**Final Acceptance Punchlist**  
**El Paso County – Department of Public Works - Stormwater Section**

Project Name:	Redtail Ranch
EDARP Filing Number(s):	SF1821
ESQCP Number:	ESQ1932
Attendees:	DPW SW: Molly Layshock, Mikayla Hartford, Glenn Reese DPW Dev Services: Developer:
Date of Walk-Thru:	05/18/2023
Walk-Thru Number:	1 <sup>st</sup> FA walk

DESIGNED BY	MAW	SCALE	DATE	07-03-18
DRAWN BY	MAW	(H) 1" = 30'	SHEET	10 OF 10
CHECKED BY	(V) 1" = N/A	JOB NO.	2525.00

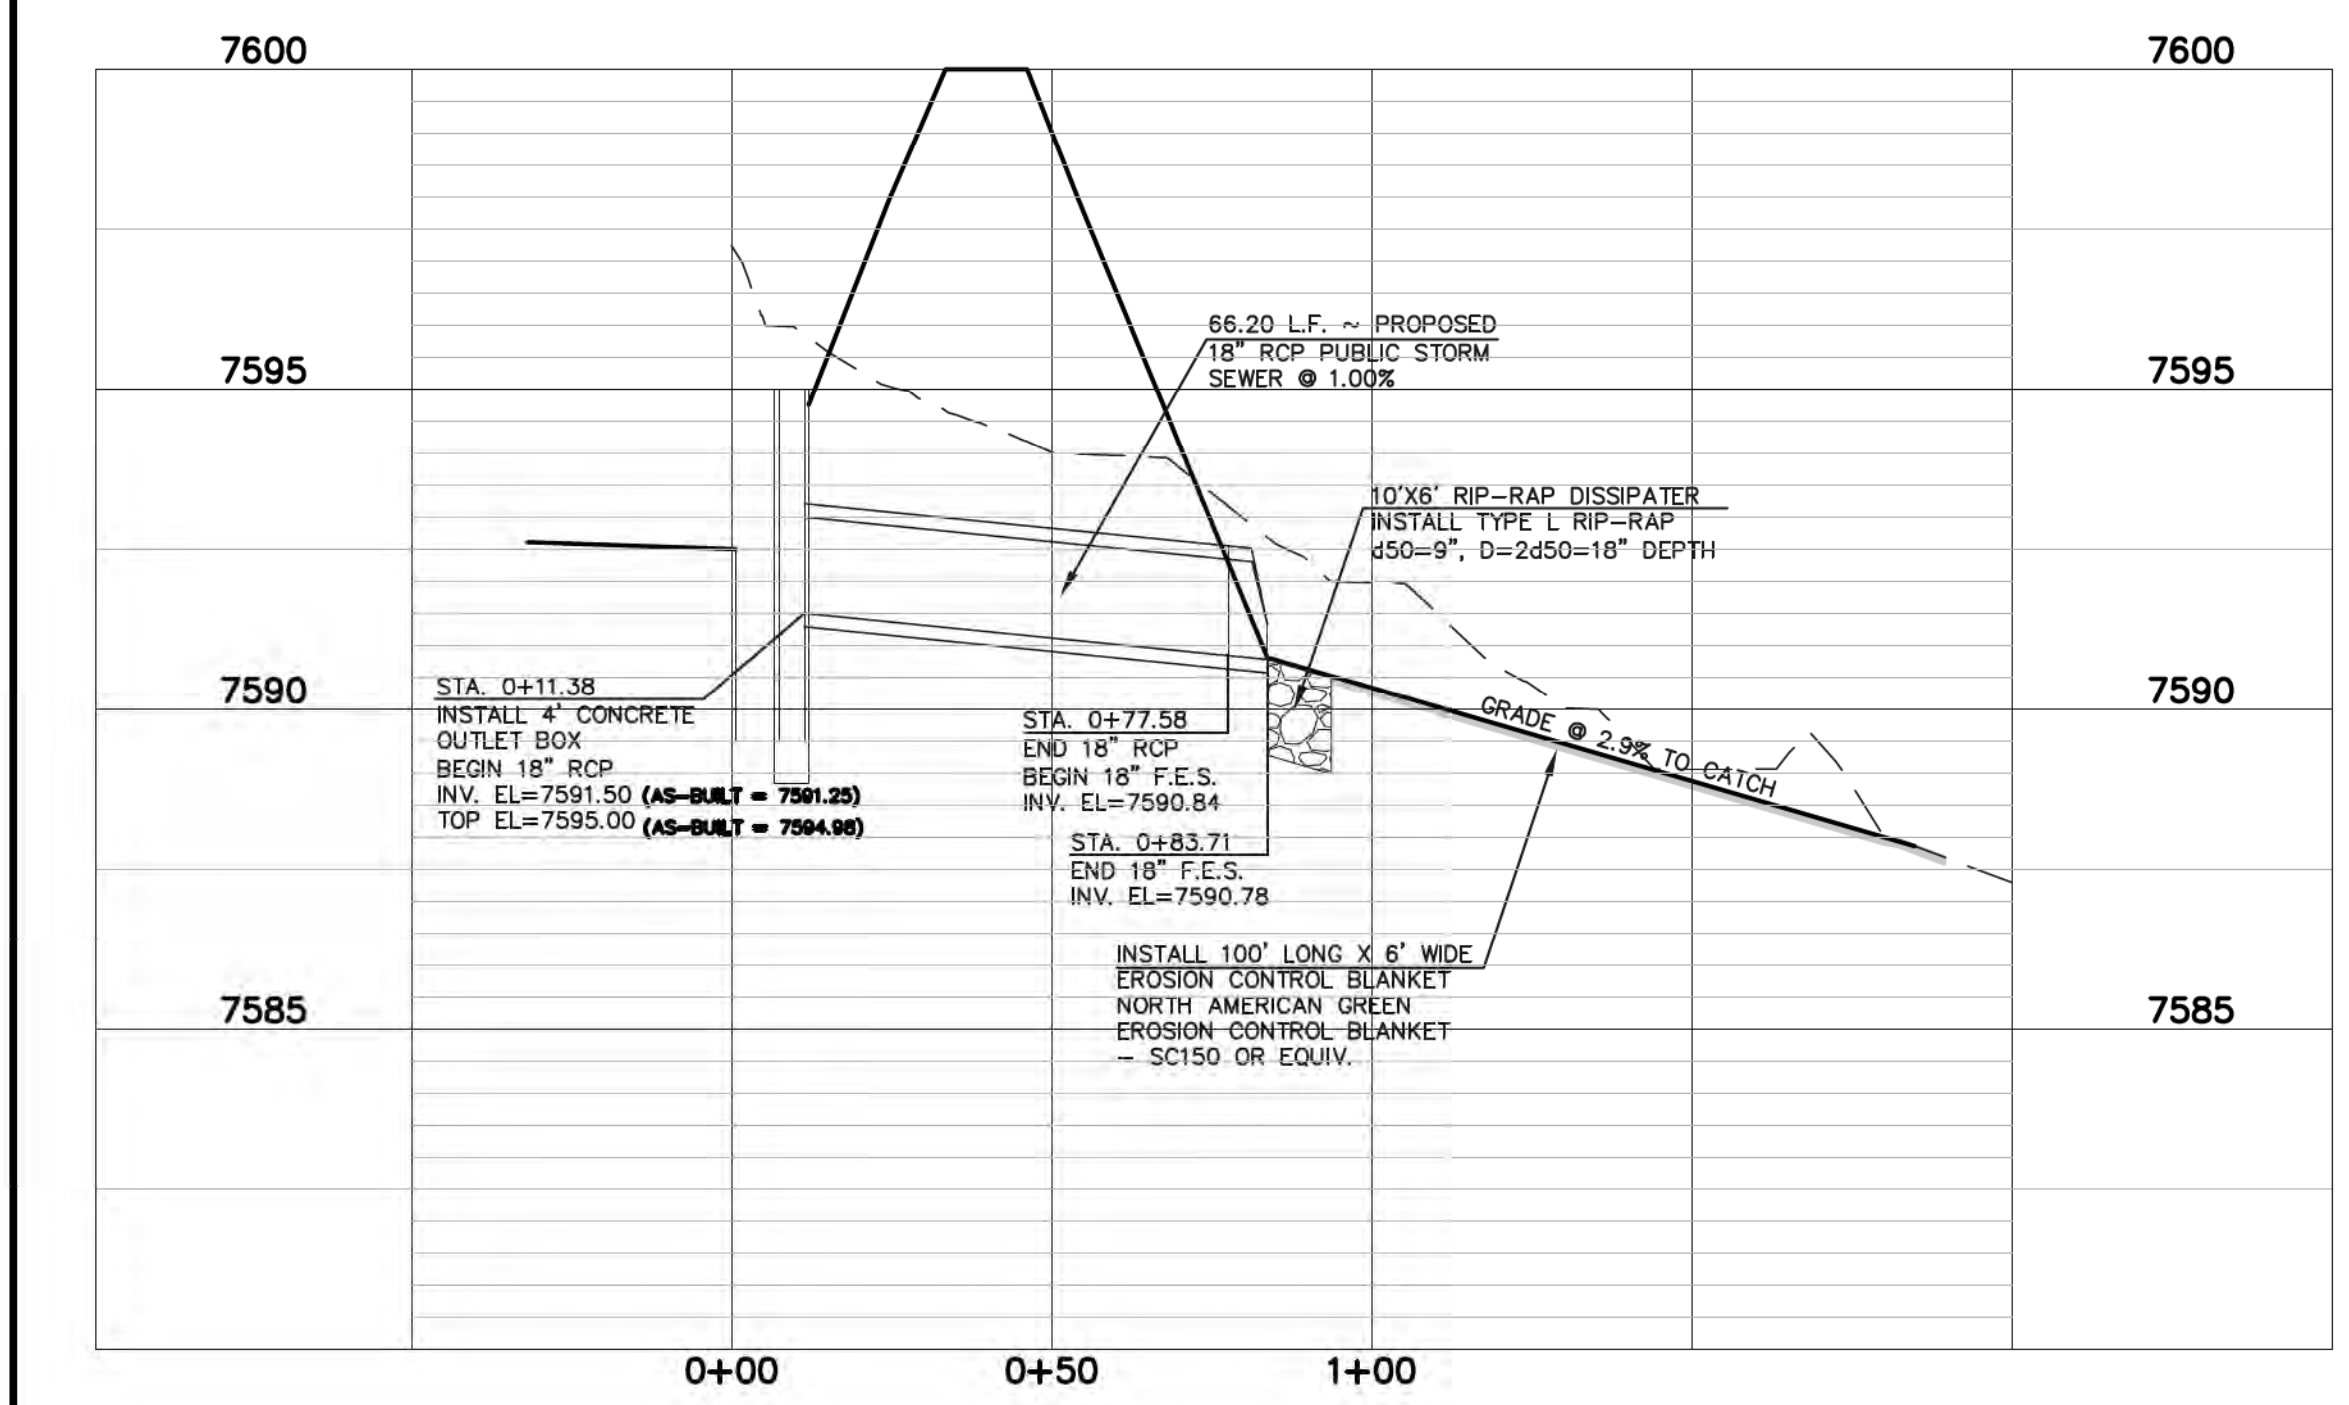
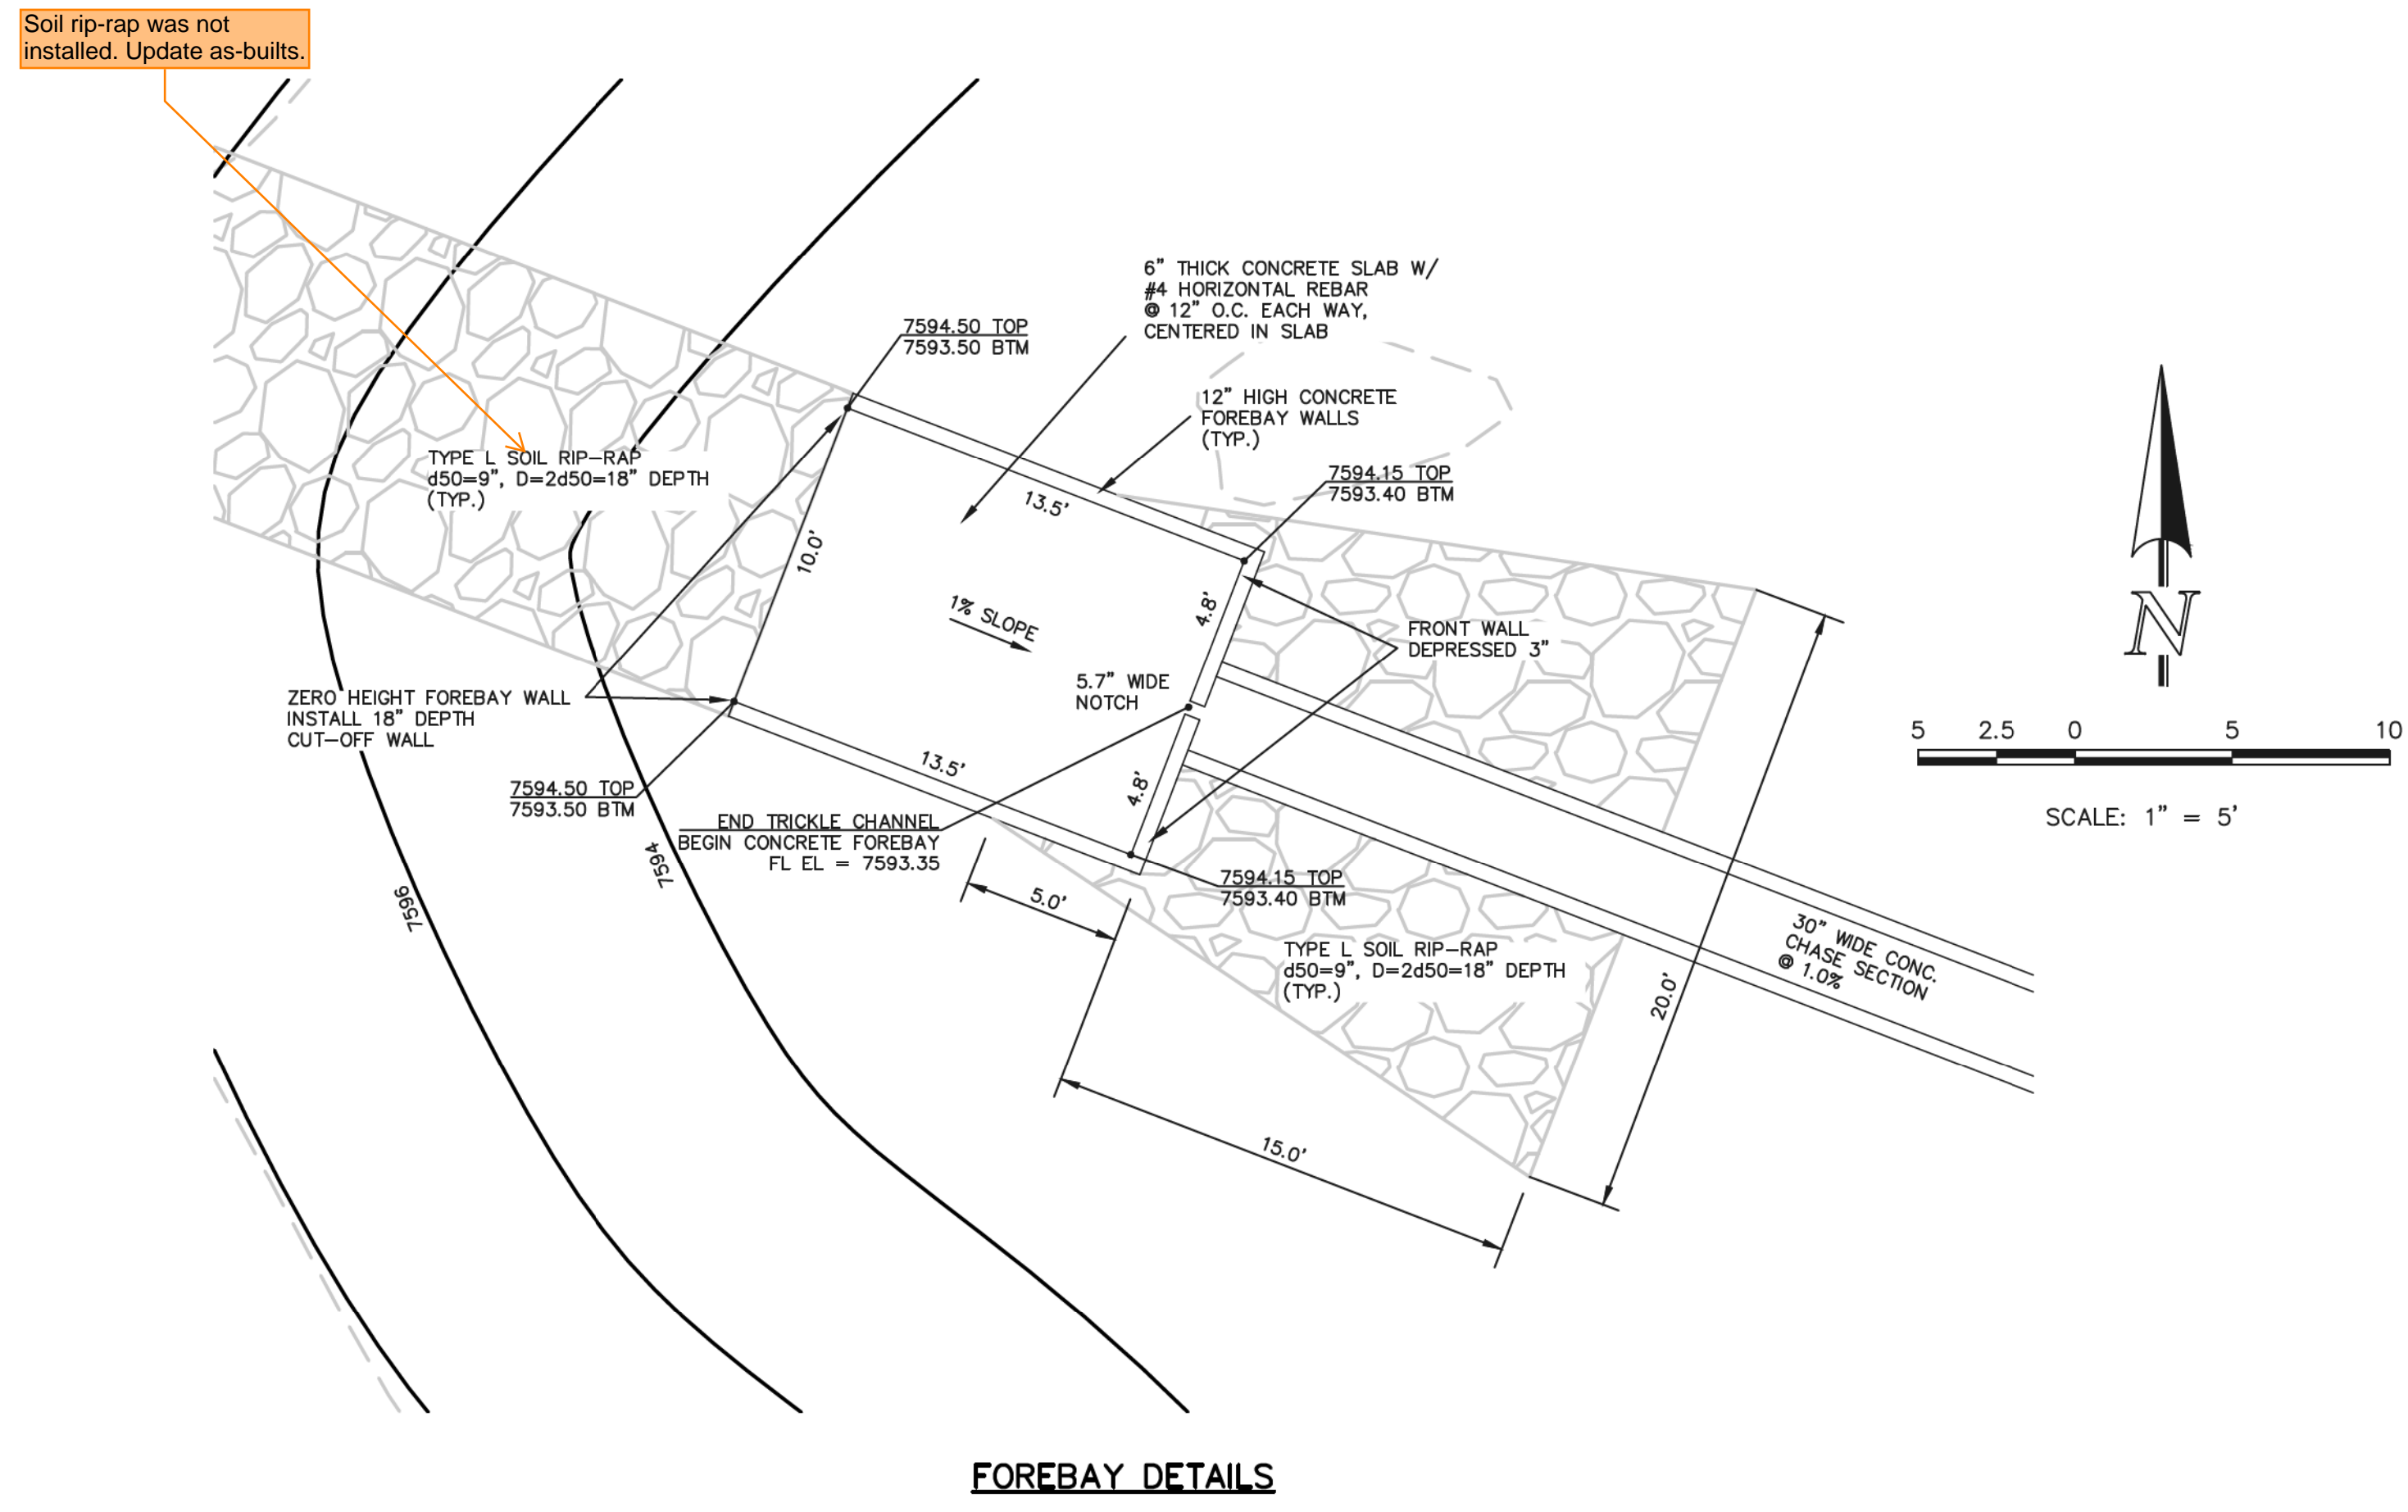
- Add white 1.5" PVC pipe to as-builts (See comments on as-builts)
- Missing rock check dam off of Sanctuary Pine Drive. Need to install per plan detail EC-12 on sheet 2 or show change on as-builts (See comments on as-builts)
- Remove debris from pond forebay
- Raise pond bottom to top of trickle channel curb with a 3% slope towards trickle channel for positive drainage
- Address shoulder riling along forebay

- Update as-builts to change soil riprap called out on sheet 10 of the plans to be riprap reflecting the change observed in the field. (See comments on as-builts).
- Clean out sediment from the outfall pipe flared end section, it is holding water
- Wrong well screen is installed in the field. Install proper well screen, diamond well screen is not permitted.
- Downstream of the outlet: remove rock socks from in front of the culvert under Vollmer Road. Regrade so that no ponding occurs. All temporary control measures must be removed prior to FA. (See photo 3)
